Address: Clough Head, Slaithwaite Gate, Huddersfield, hd7 4nw

Application number: 2026/91445	
What is the application for?:	Demolition of existing garage/storage building and erection of two storey dwelli
Address of the site or building:	1, Clough Head, Slaithwaite Gate, Bolster Moor, Huddersfield, HD7 4NW
Postcode:	HD7 4NW

Type of comment: An objection	
Do you wish your comments to be published on the website anonymously?	No
Further comments linking to submission FS-Case-846667594

PROJECT
PROPOSED DWELLING HOUSE
1 CLOUGH HEAD
BOLSTER MOOR
HUDDERSFIELD
HD7 4NW
DRAWING TITLE
PROPOSED GROUND & FIRST FLOOR PLANS

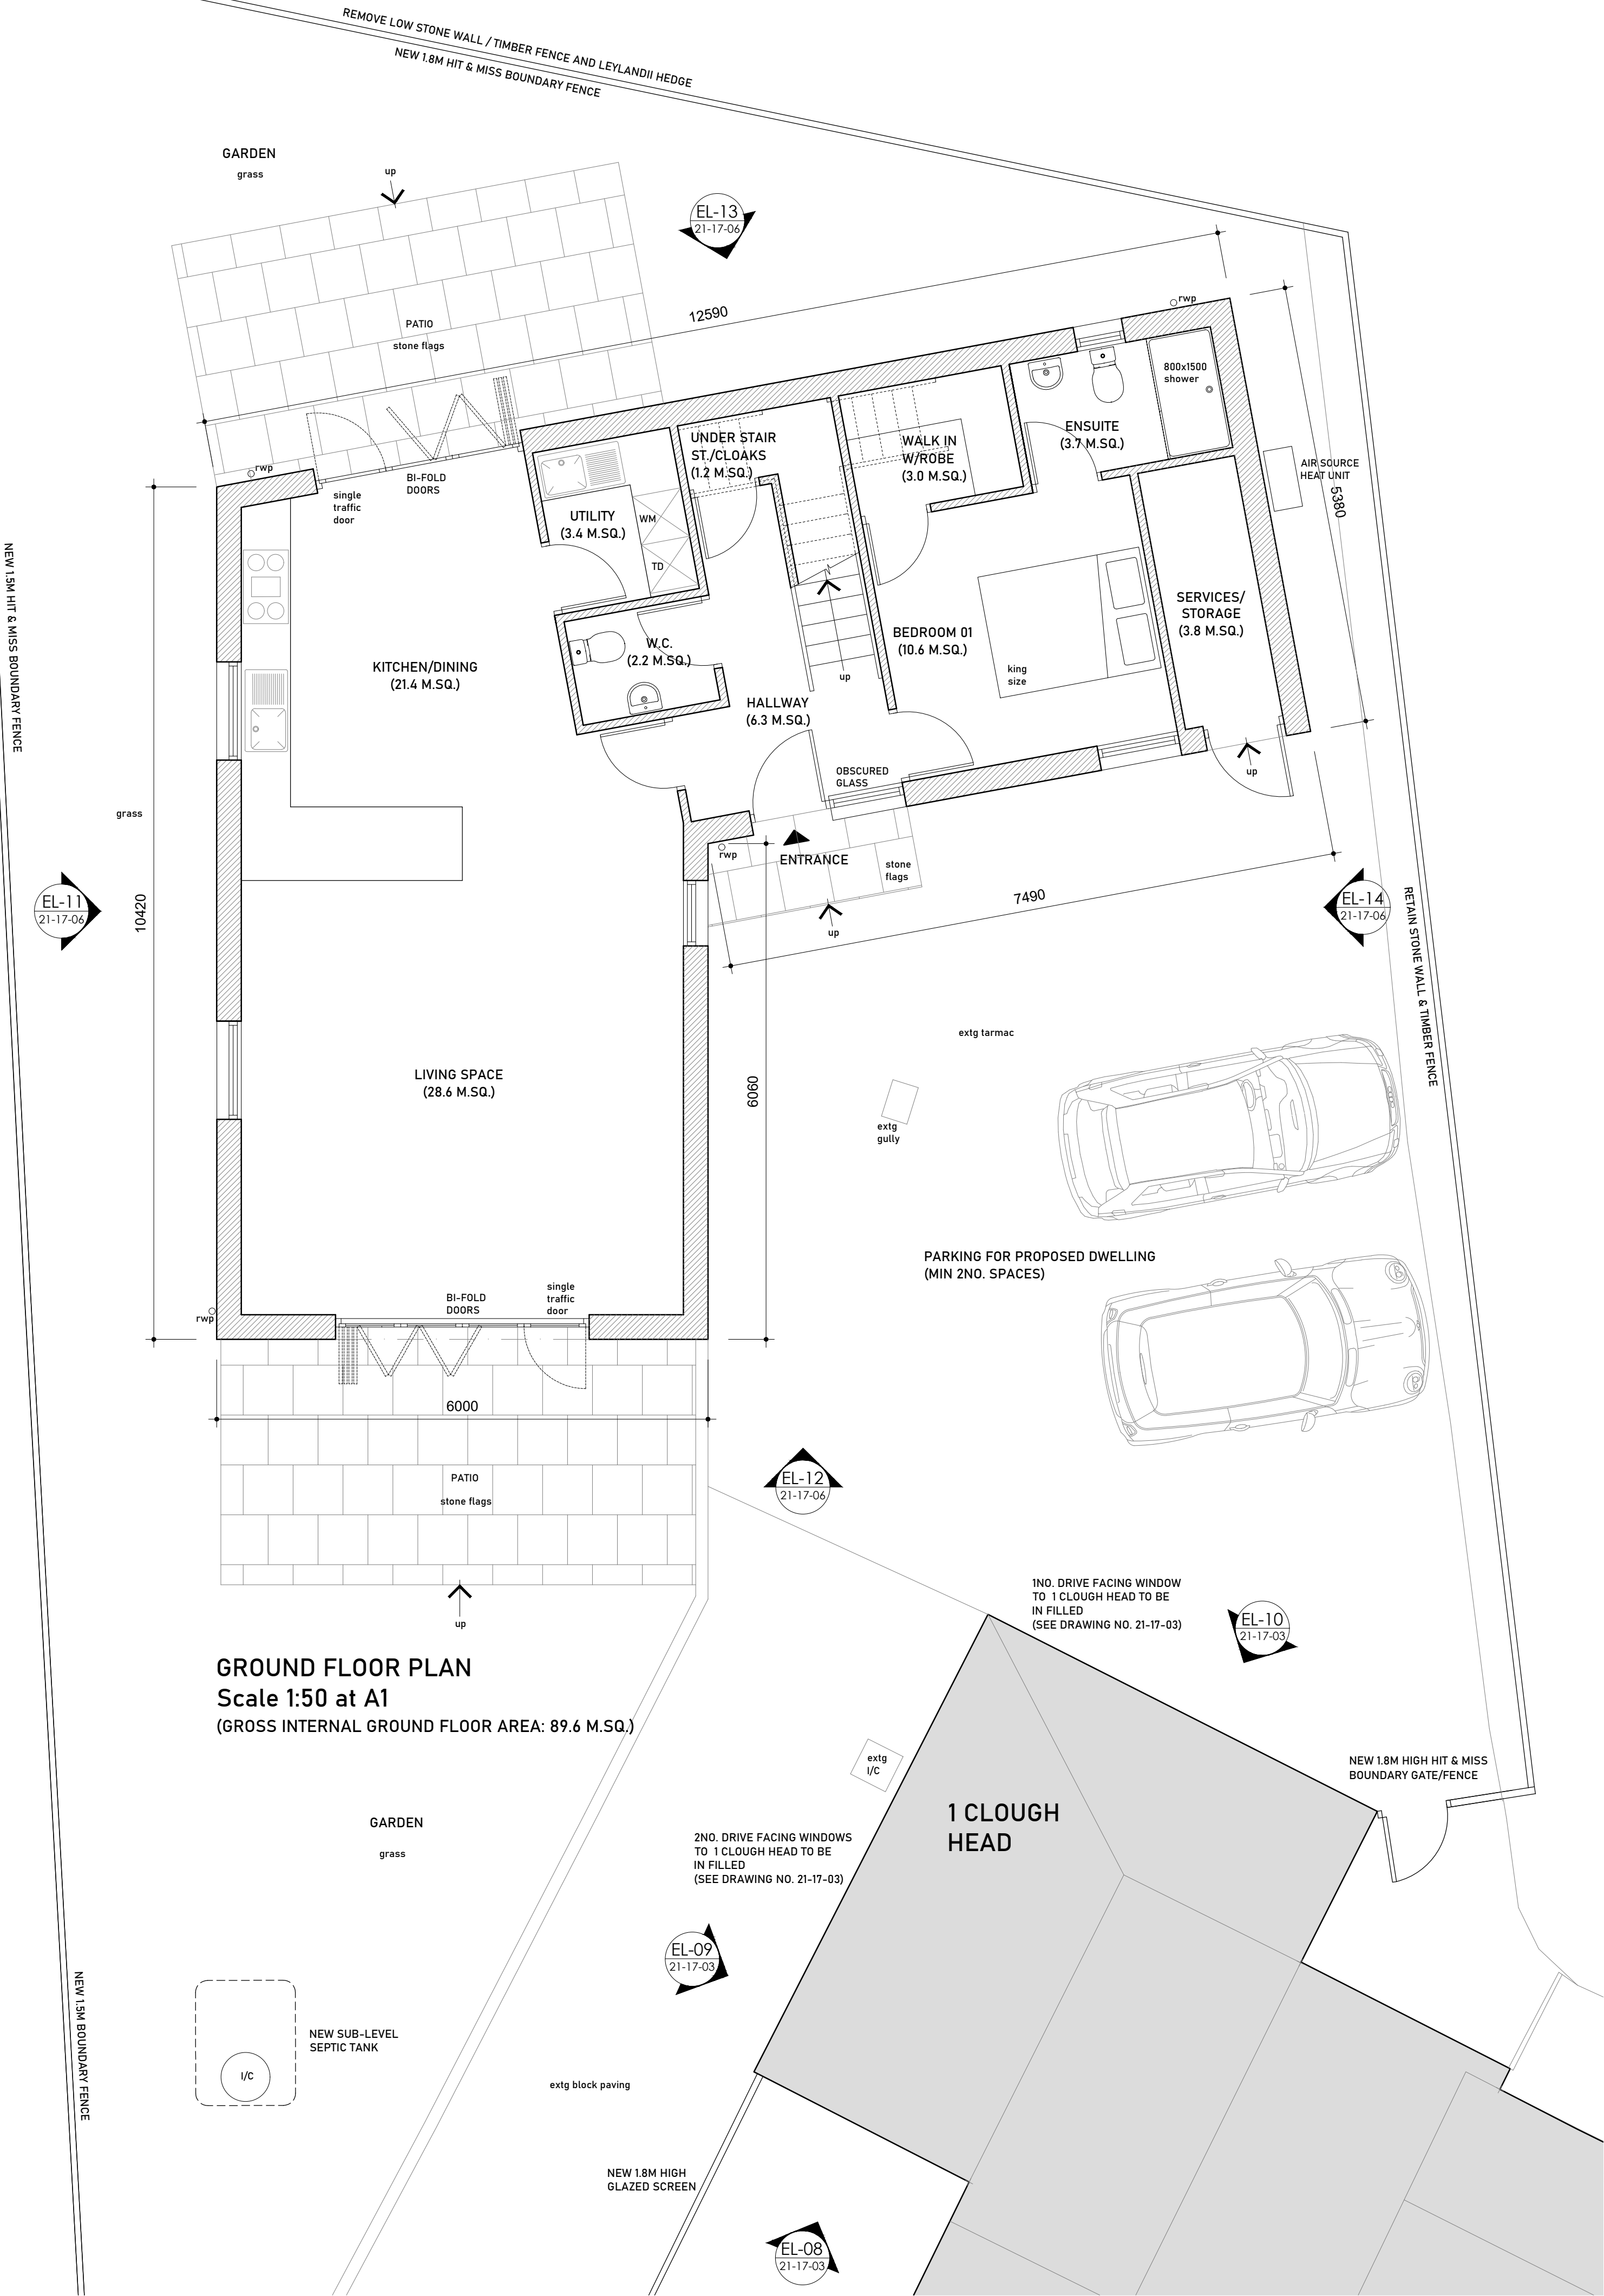
The proposed development would introduce a substantial two-storey structure with first-floor windows providing elevated and direct views into the garden, patio area and towards the main living space.

Given the height of the proposed building, existing boundary treatments would not provide effective screening from upper levels. This would result in a material and harmful change in the relationship between the properties, leading to increased overlooking, loss of privacy, and a more dominant and intrusive built form.

The submitted drawings do not fully convey the extent of overlooking, visual dominance or the effects of the elevated position of the development. Assessment from neighbouring land would provide a more accurate understanding of these impacts.
